**REQUEST**

Current Zoning: MUDD-O (mixed use development district, optional) and N1-A (neighborhood 1, A)  
Proposed Zoning: RAC(CD) (regional activity center, conditional)

Approximately 2.28 acres located on the east side of Apex Drive and north side of Coltsgate Road, west of Cameron Valley Parkway.

The petition proposes a multi-family residential development as part of the Apex Southpark project on parcels currently developed with surface parking and one single family home.

TECHNICAL DATA SHEET

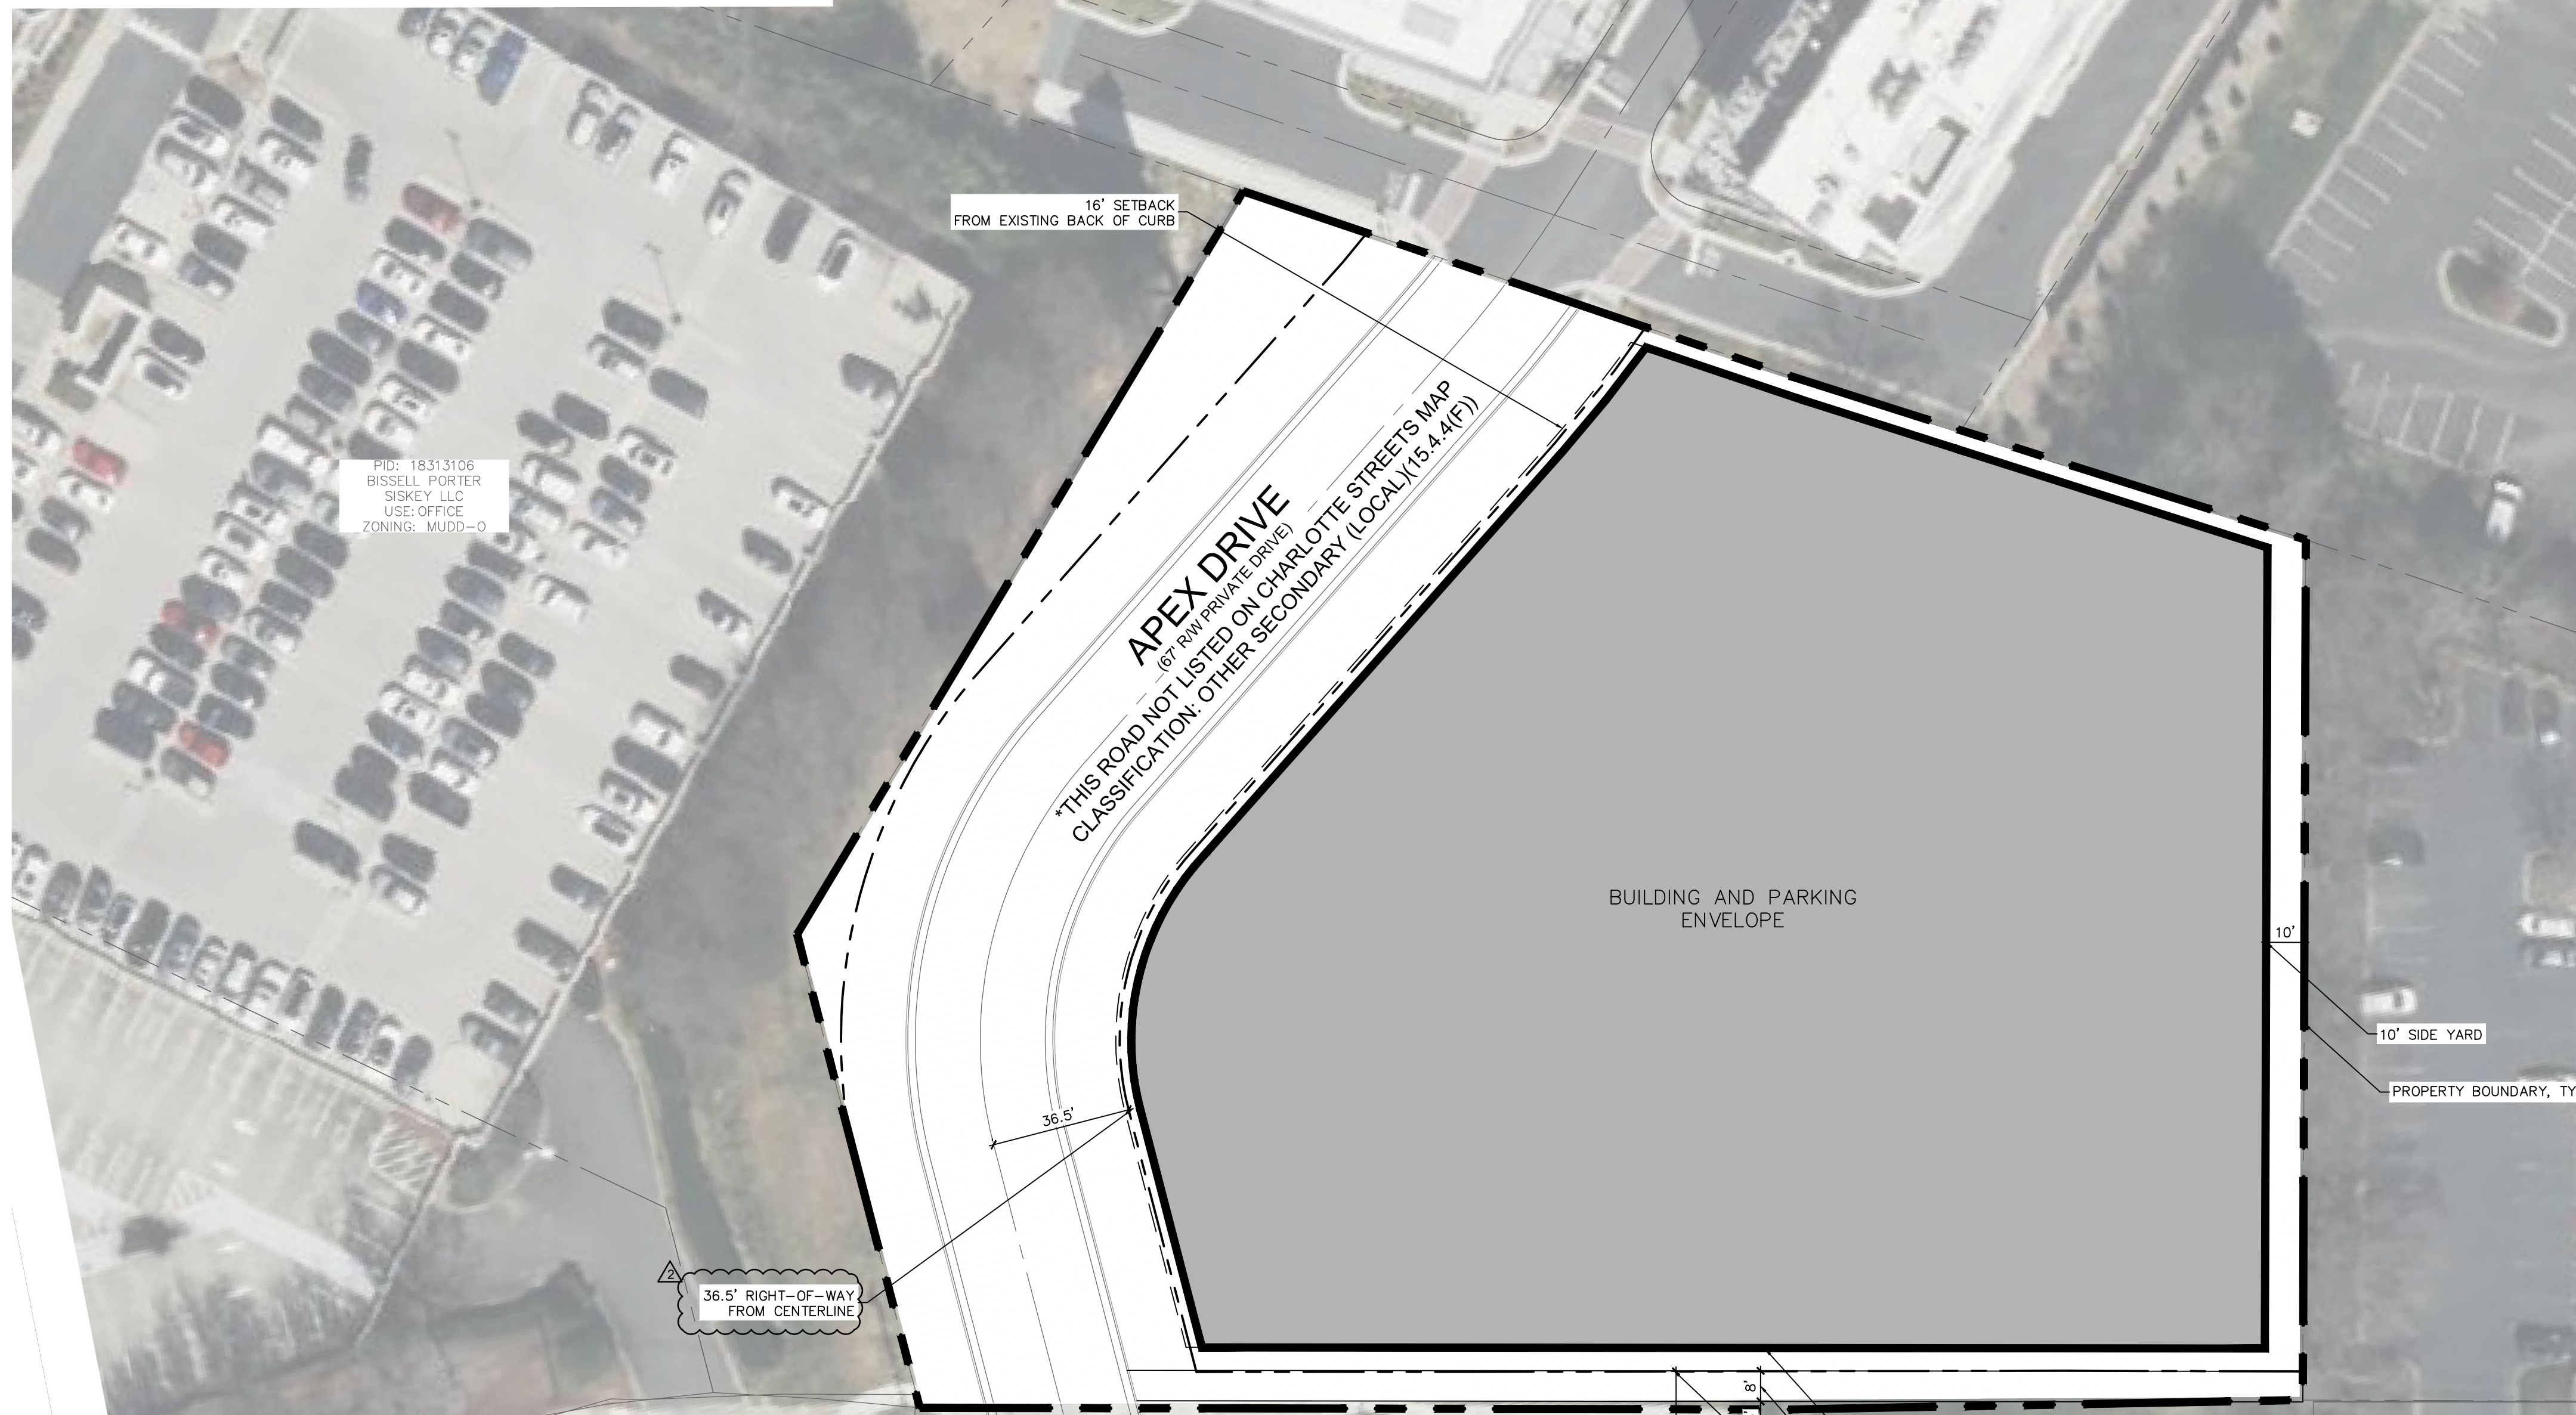
3. ~~Revise Note 1. of the Storm Water Quality Treatment conditions to specify 24% rather than 25%.~~ **Addressed**
-

RZ1.00

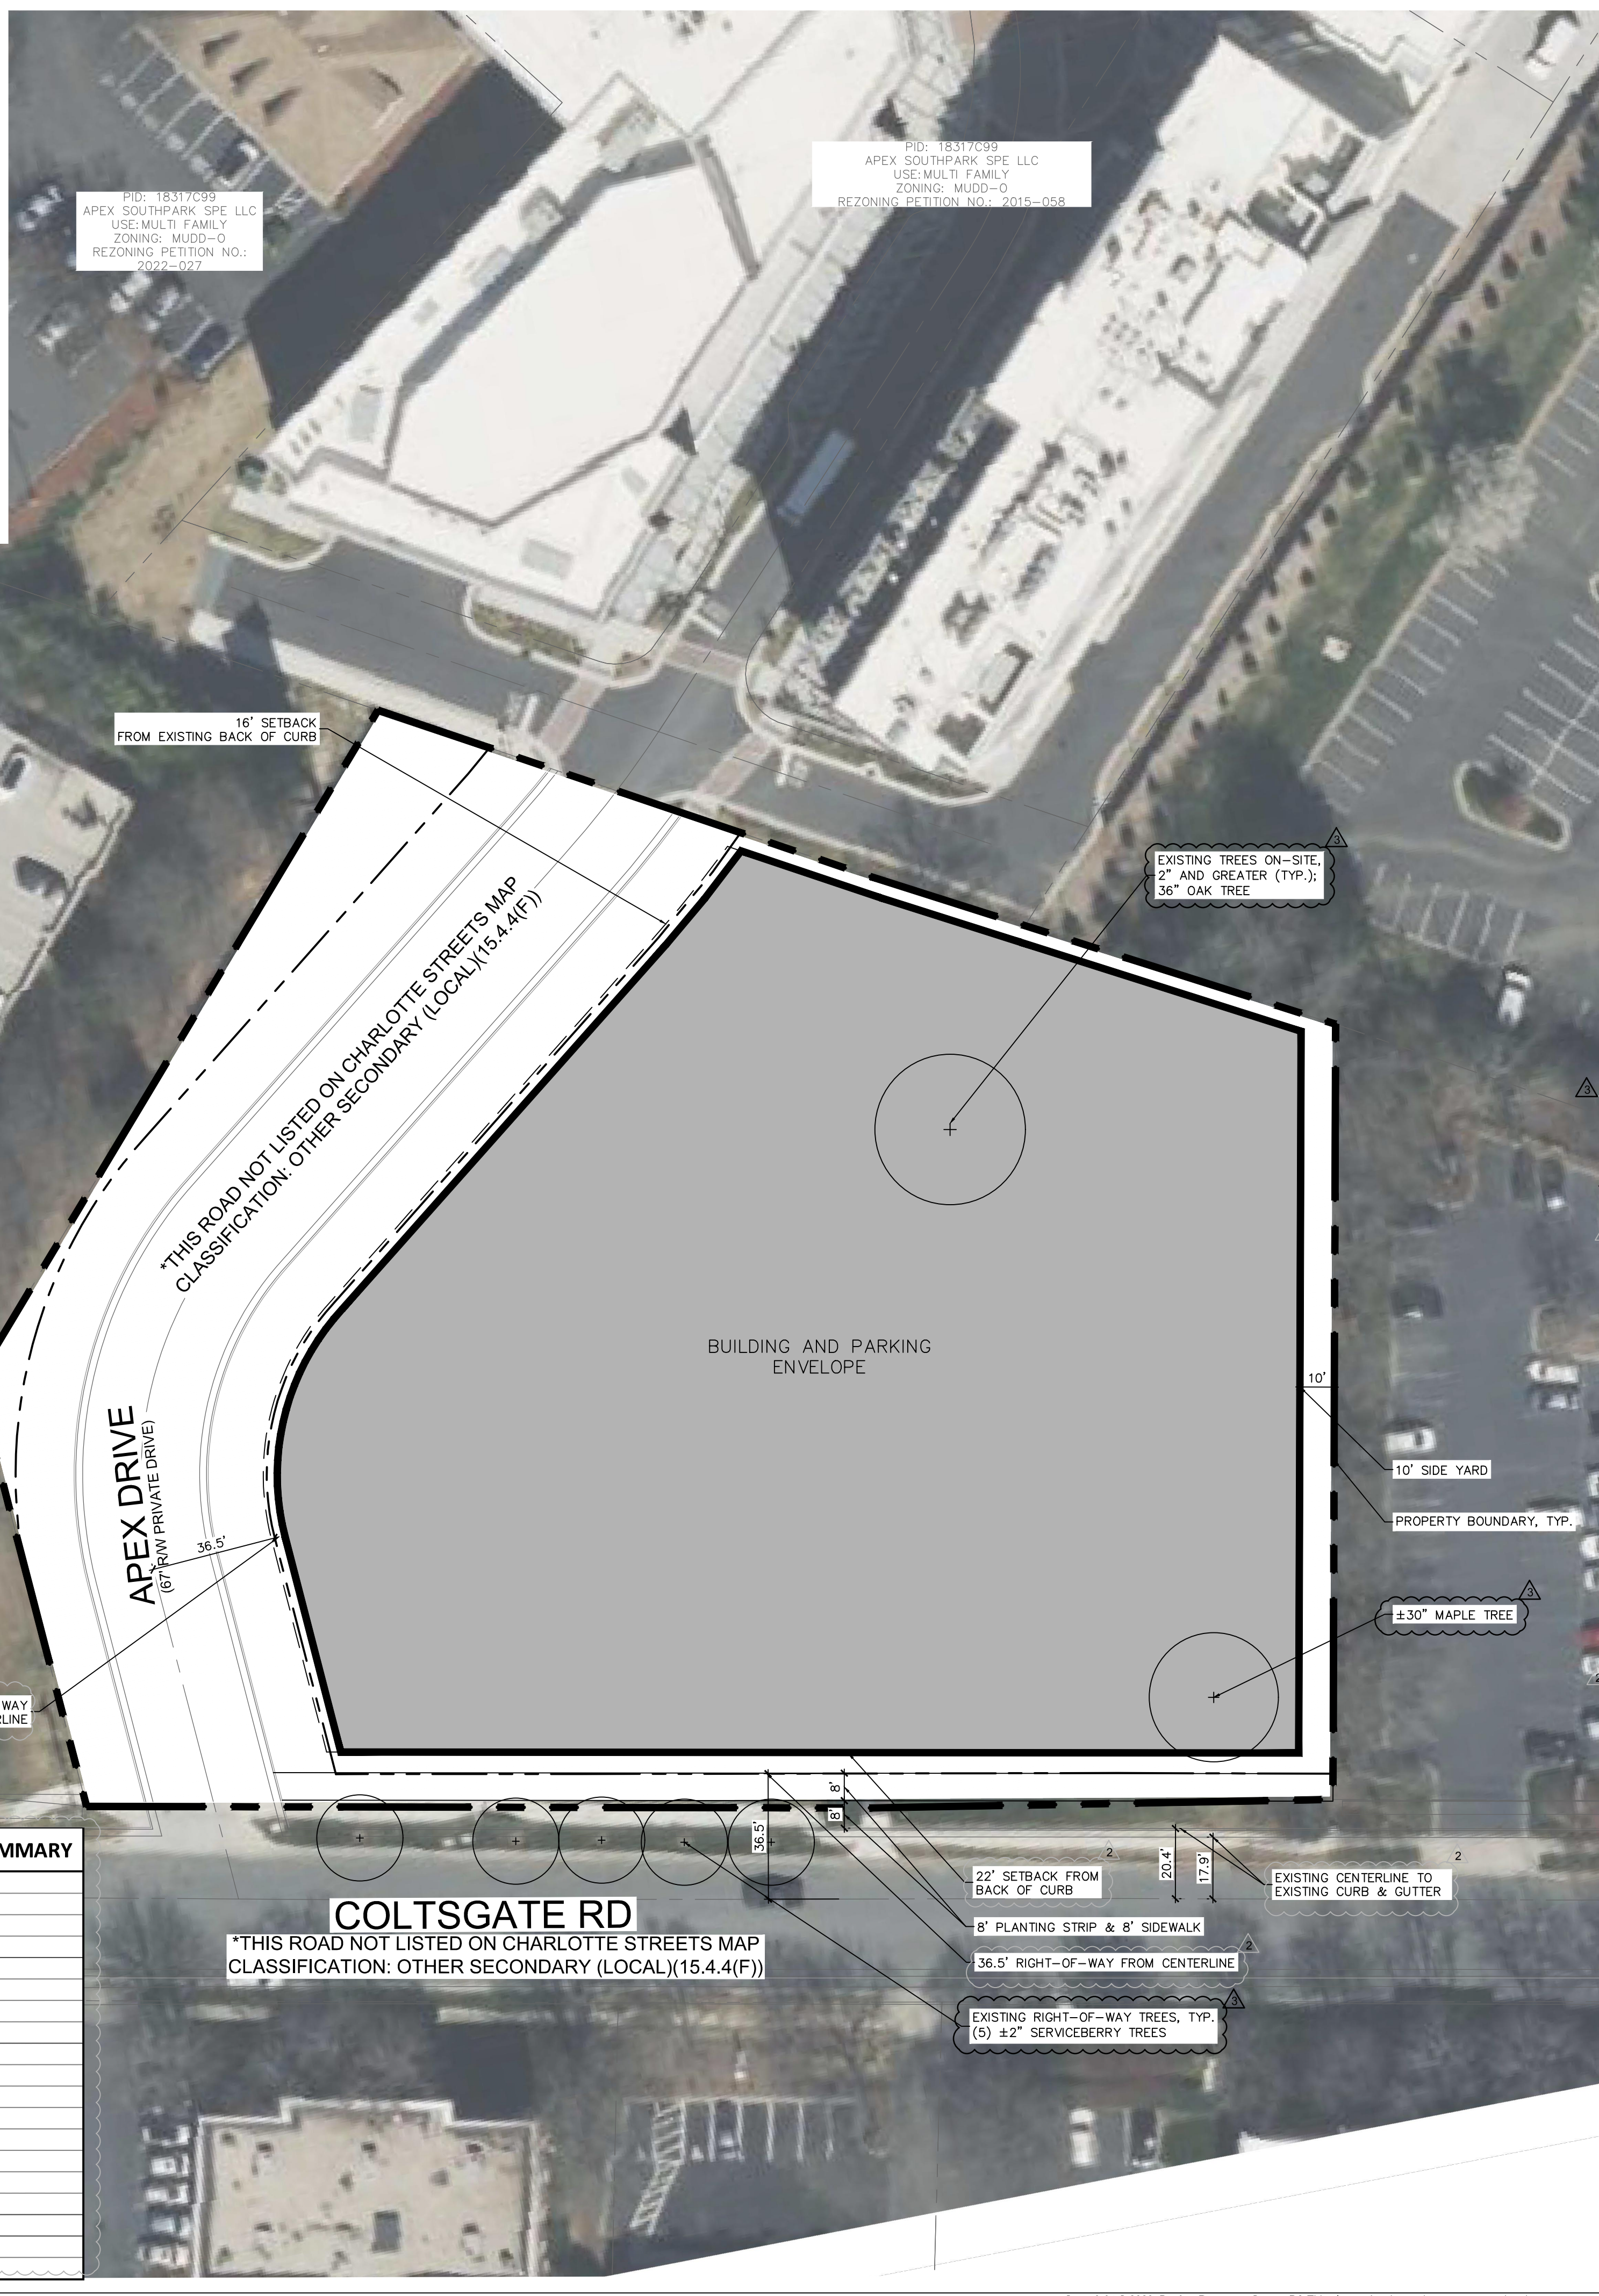
2. ~~Add a note specifying that any height above 150' will be achieved utilizing development bonus standards outlined in Article 16 of the UDO.~~ **Addressed**
